**KIRKLEES METROPOLITAN COUNCIL  
INVESTMENT & REGENERATION SERVICE**

**DELEGATED DECISION TO DETERMINE PLANNING APPLICATIONS**

Reference No:	<b>2024/62/93571/W</b>
Site Address:	14, Smithy Close, Lindley, Huddersfield, HD3 3ZB
Description:	Demolition of existing garage and erection of detached garage and alterations to existing dwelling
Recommending Officer:	Joanna Rednall

**DECISION – CONDITIONAL FULL PERMISSION**

Proposed Floor Plan & Block Plan

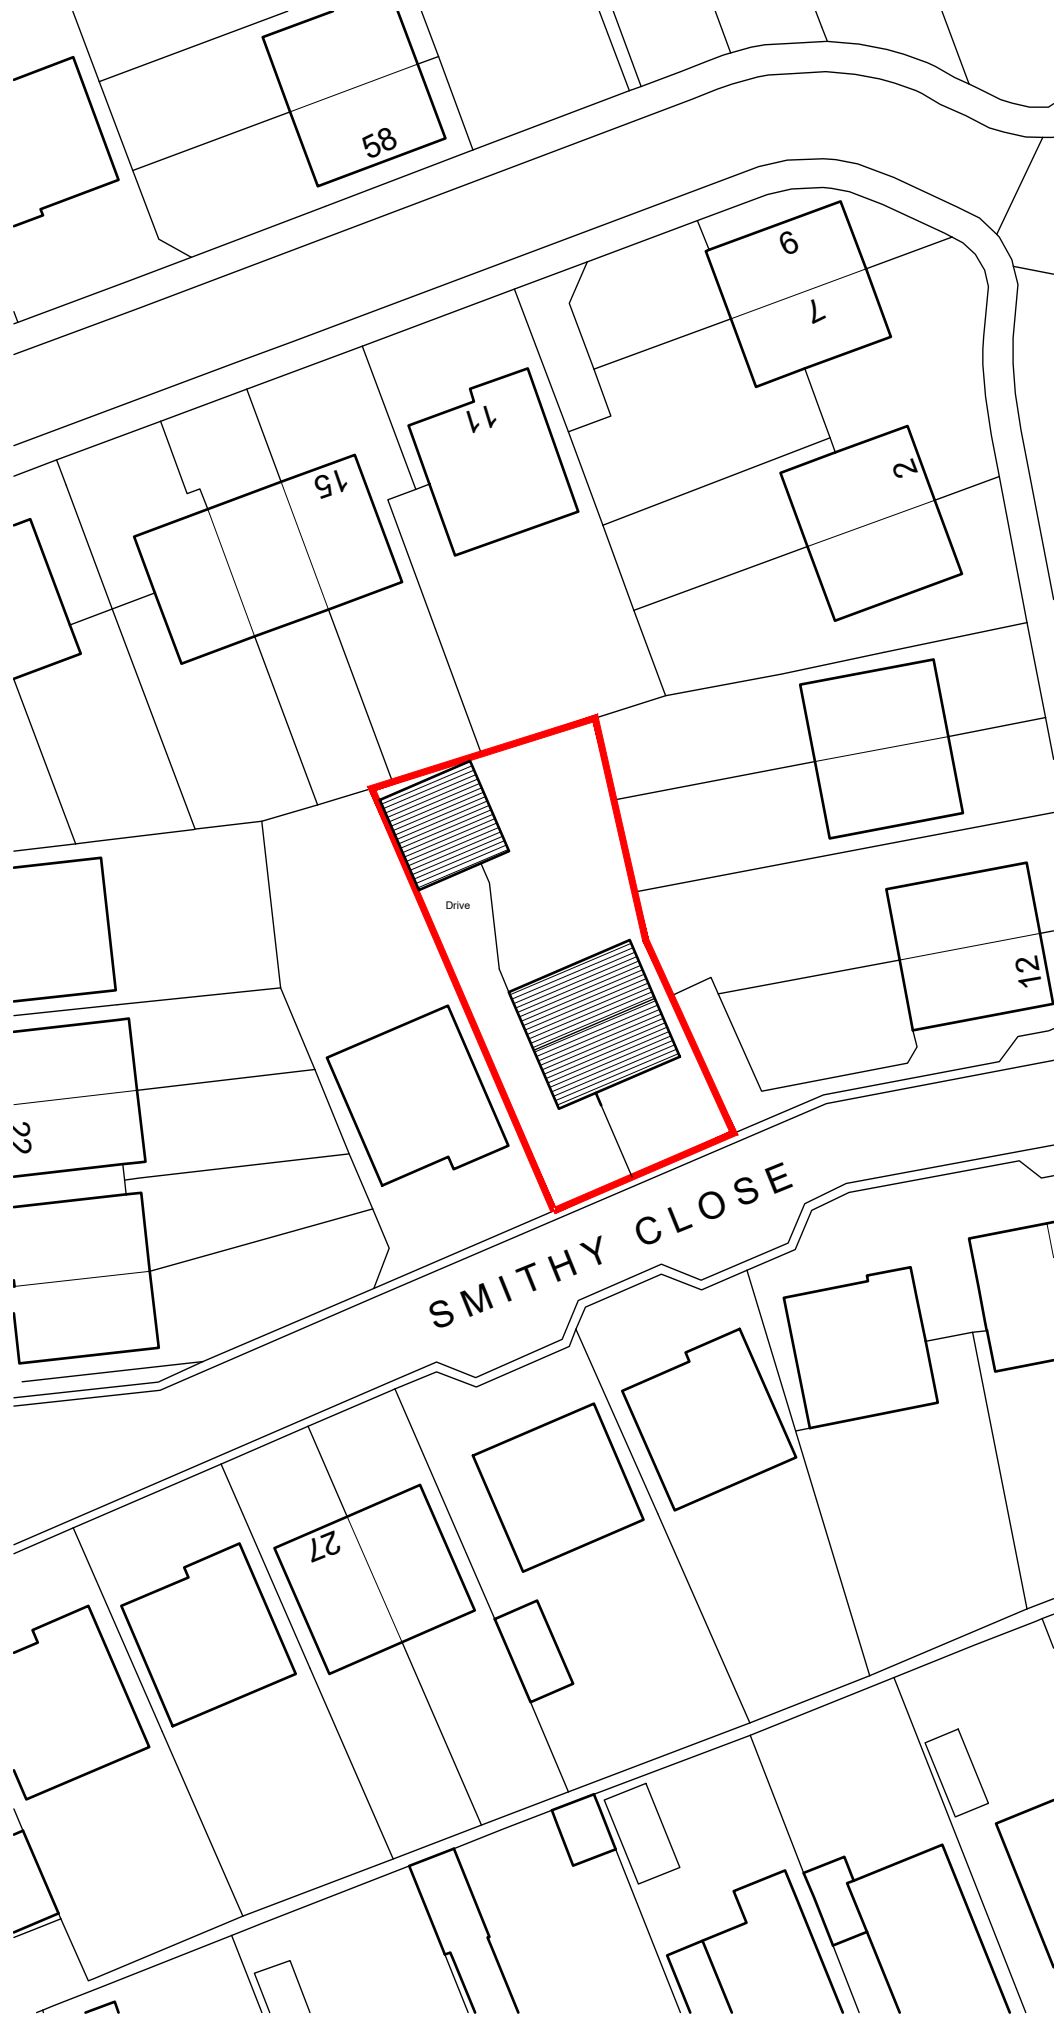
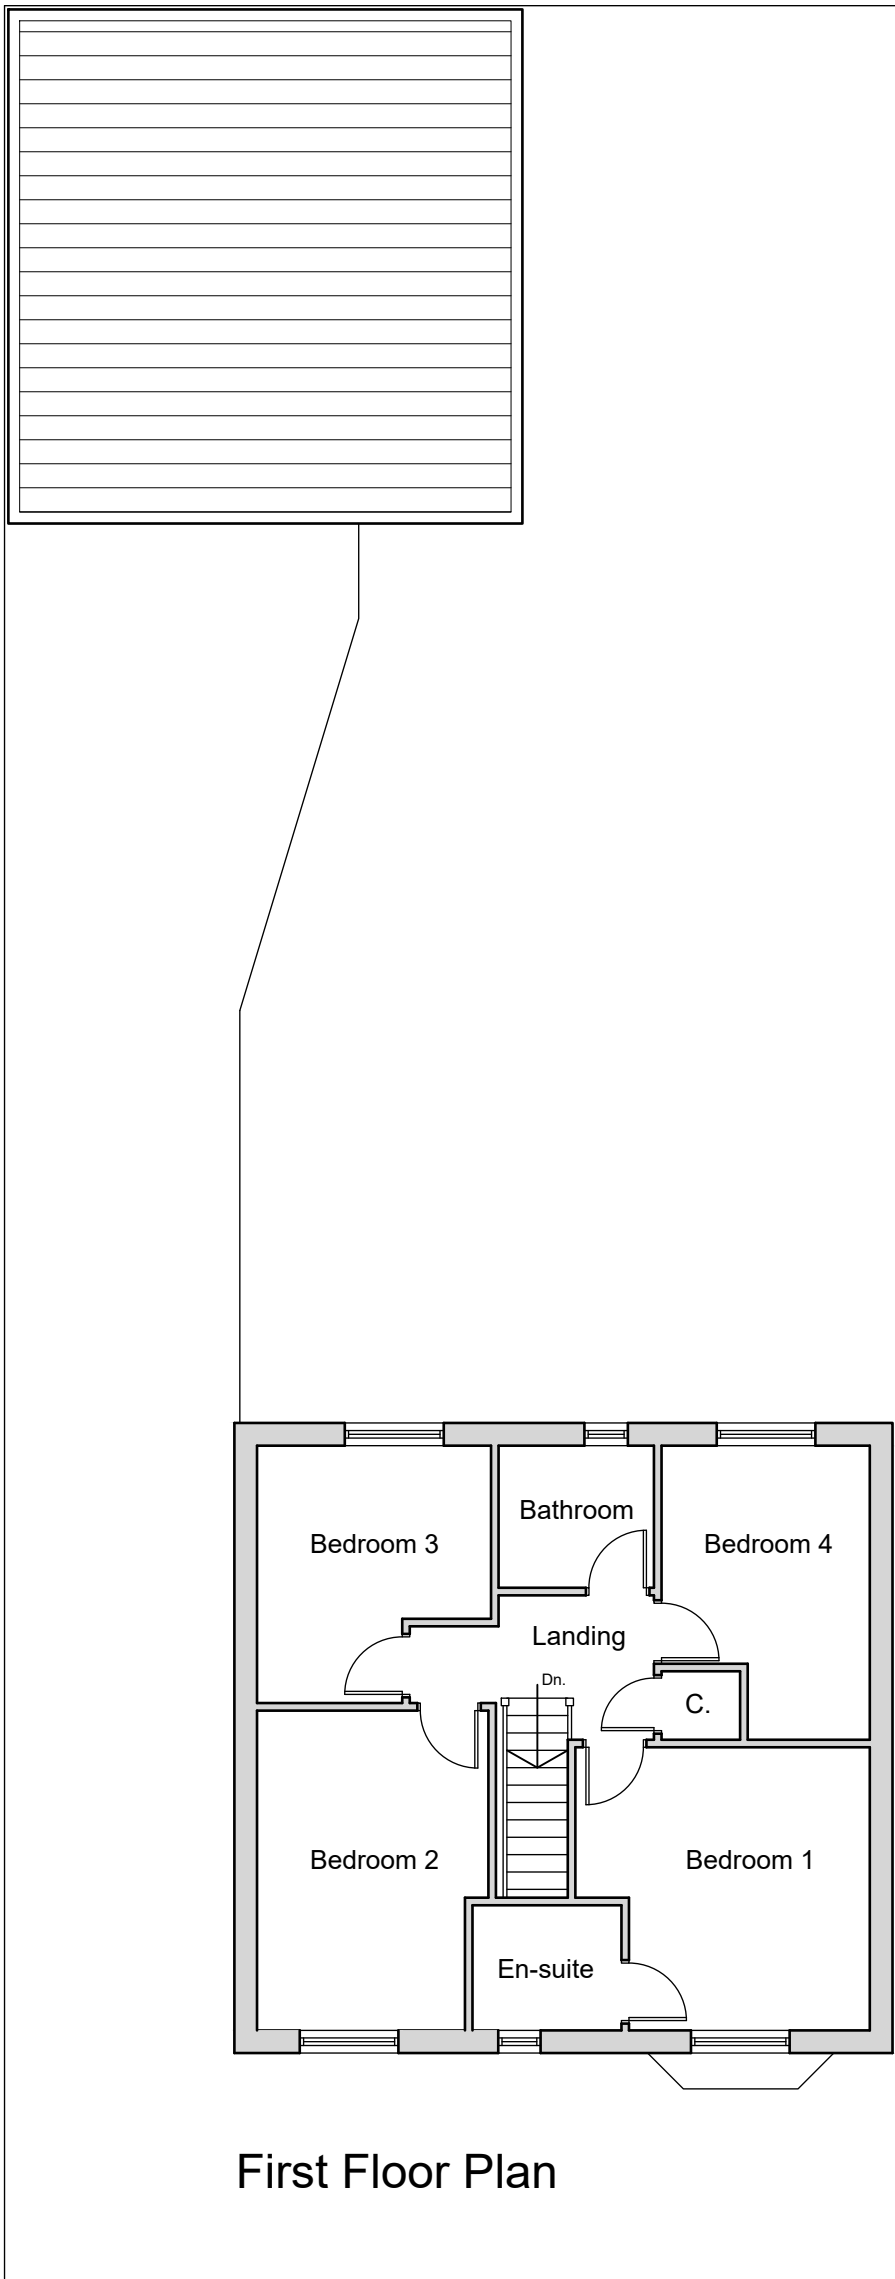
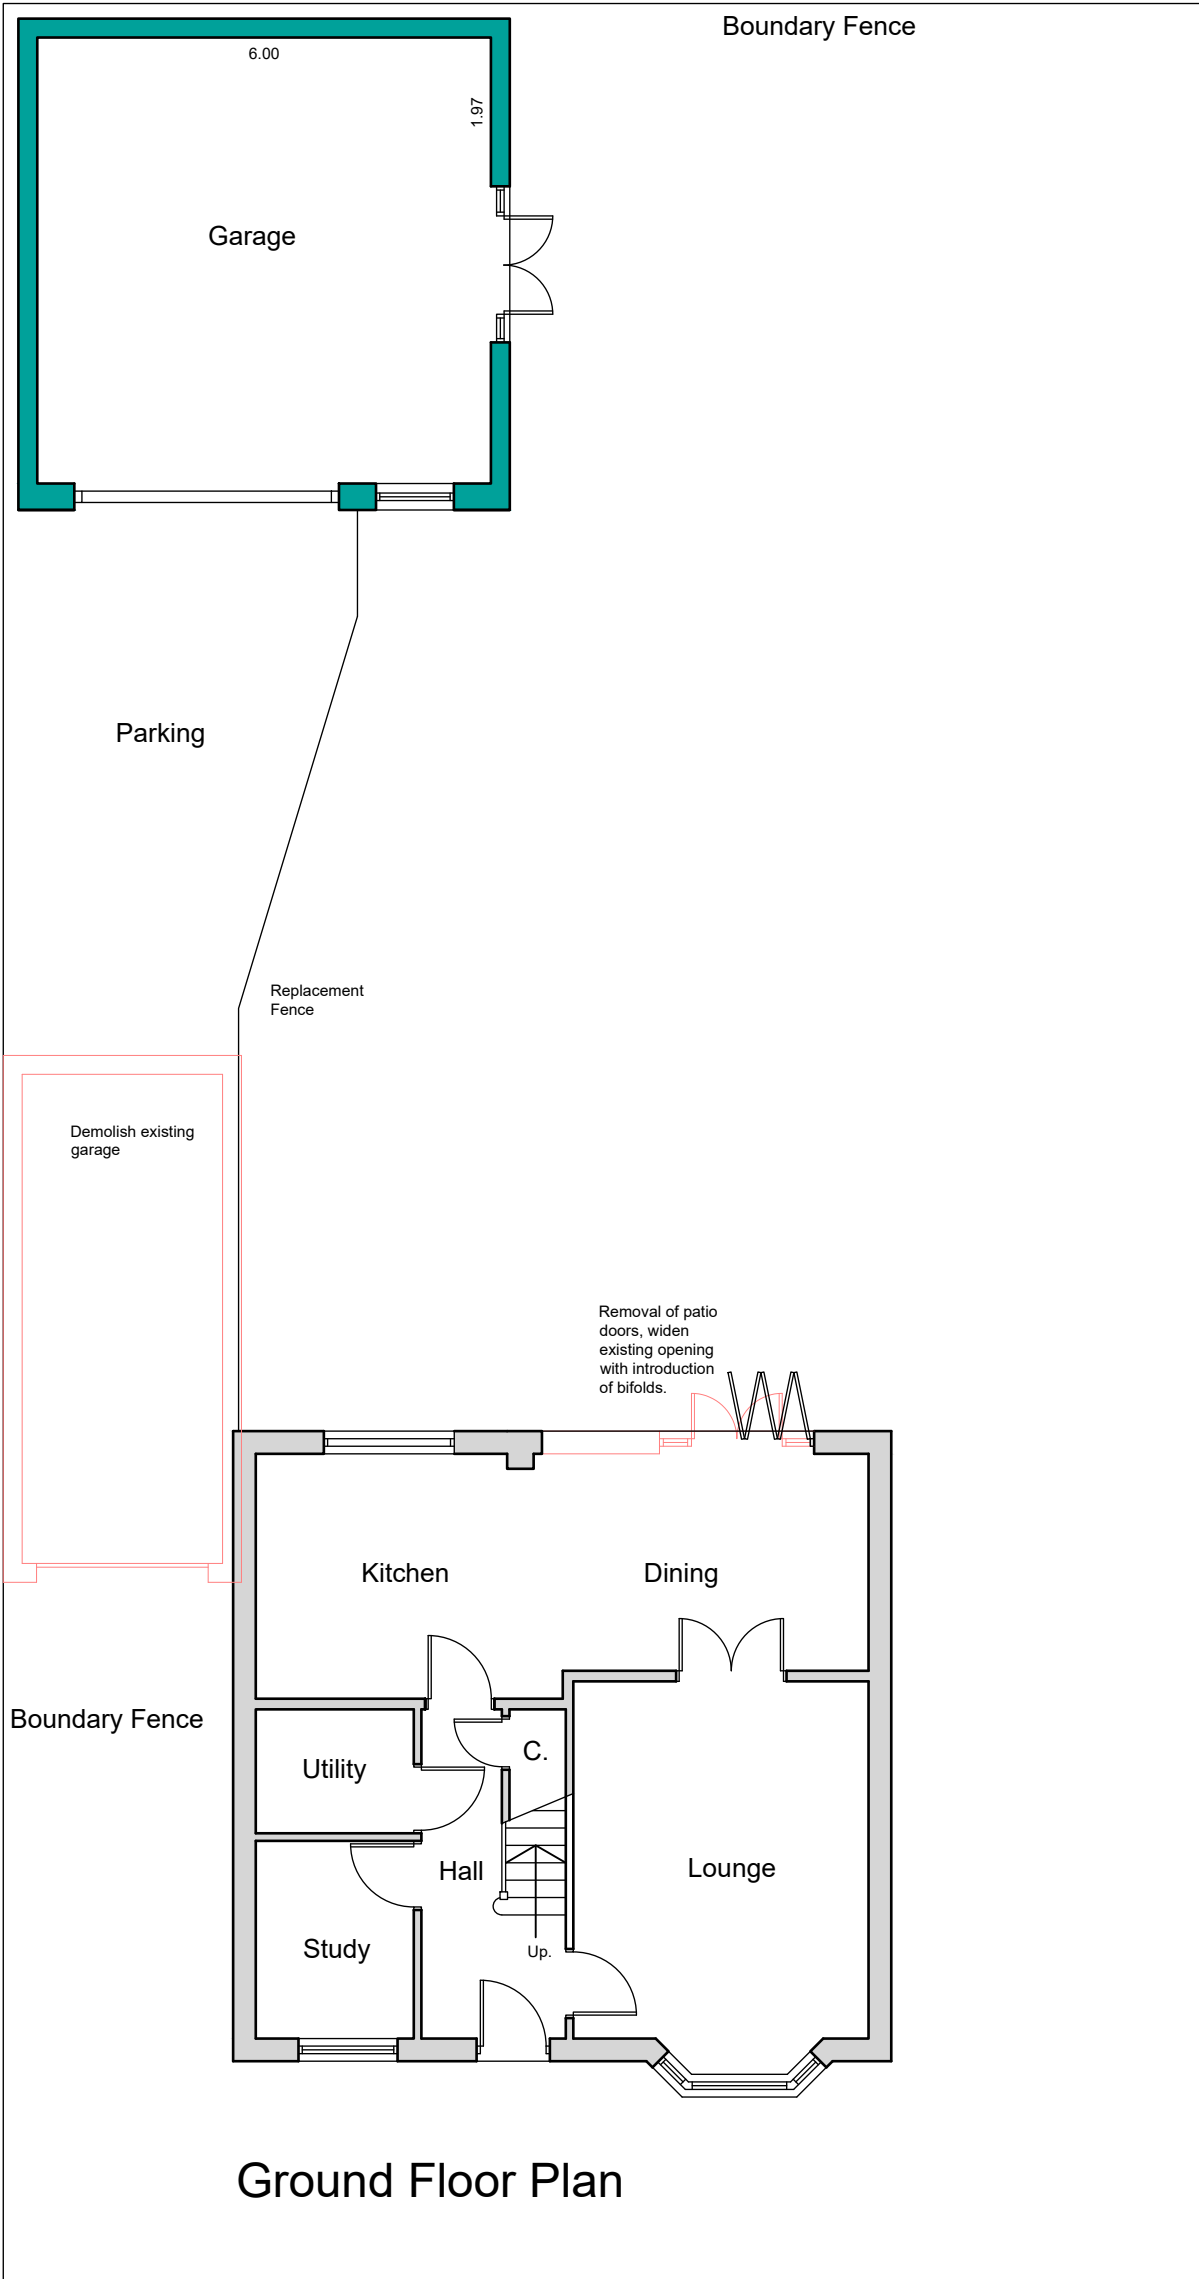
The submitted plans show the area to the side and rear of the dwelling would be hard-surfaced leading up to the proposed garage and the climate change statement sets out this will be permeable surfacing.

Alterations are proposed to the rear elevation of the dwelling, this is in the form of removing the existing patio doors, widening the existing opening, and inserting bi-folding doors.

Proposed Block Plan

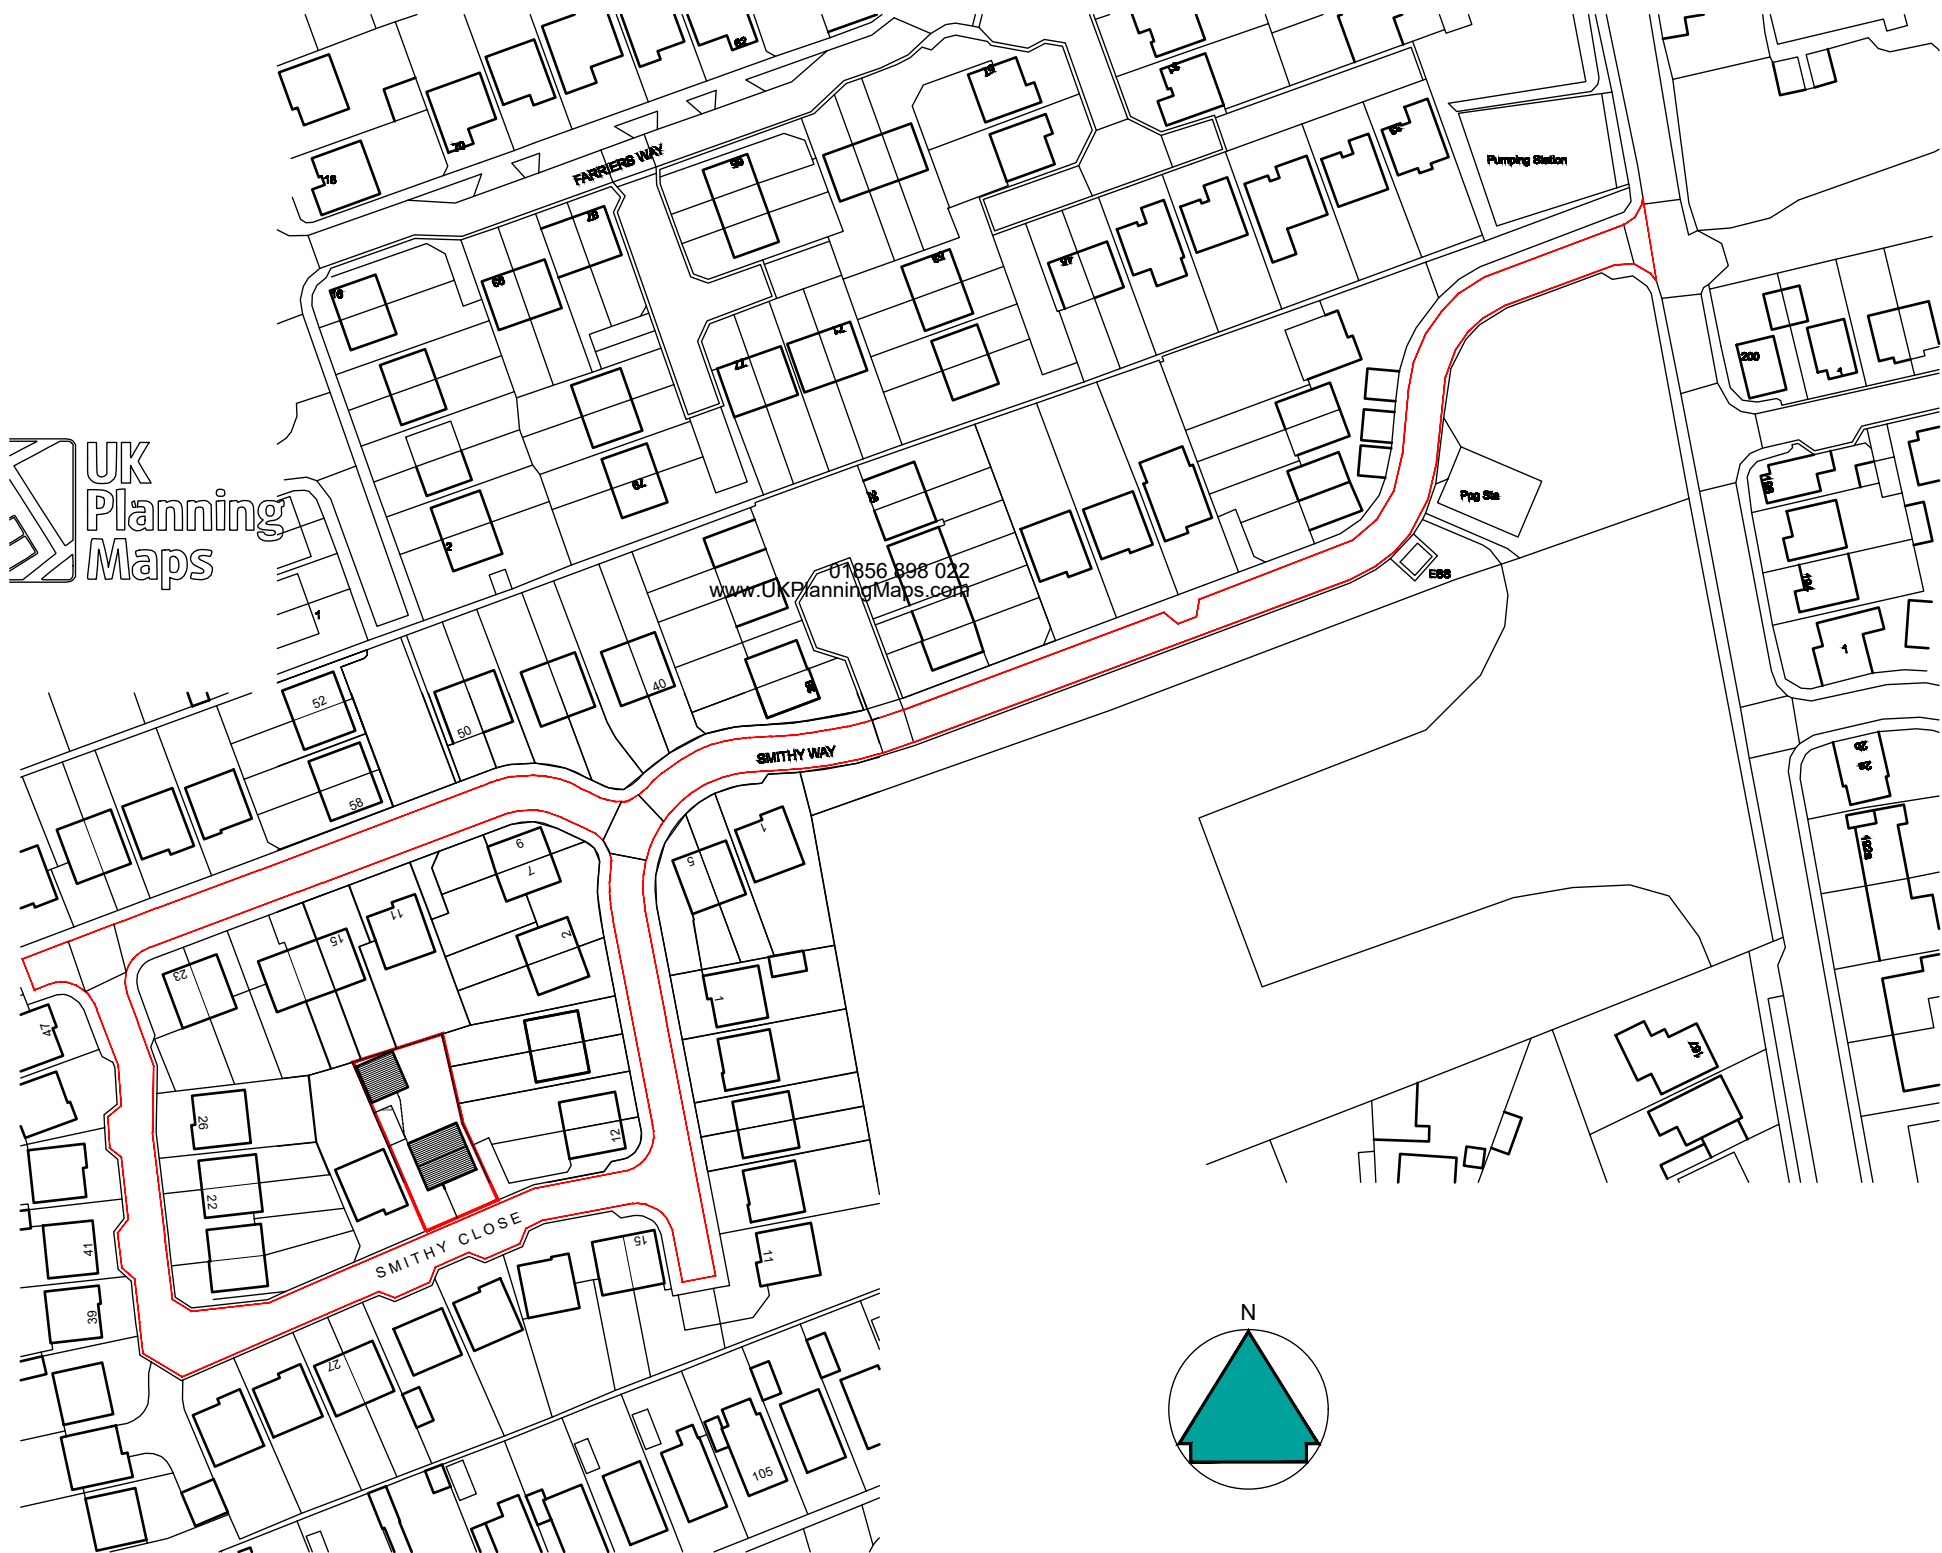
The garage would be located approximately 7.8 metres away from the common boundaries with a total of 21 metres achieved from the rear elevations of No.6 and No.8 Smithy Close. The development would also be partially screened by existing boundary treatment. Due to these reasons, the proposed development is considered to have an acceptable impact upon the amenity of No 6 & 8.

The proposed development involves the demolition of the existing garage, which will be replaced with a larger garage structure located at the rear of the garden. In addition, the driveway will be extended to provide access to the new garage. The domestic use of the application property would not change as a result of the development, therefore the proposed level of parking is considered to be acceptable. Given the scope of the works and the need to address drainage concerns, it is necessary to include a condition on surfacing and drainage to ensure that both highway and drainage requirements are met. This is in line with Policies LP21, LP22, LP24, LP28 and LP34 of the Kirklees Local
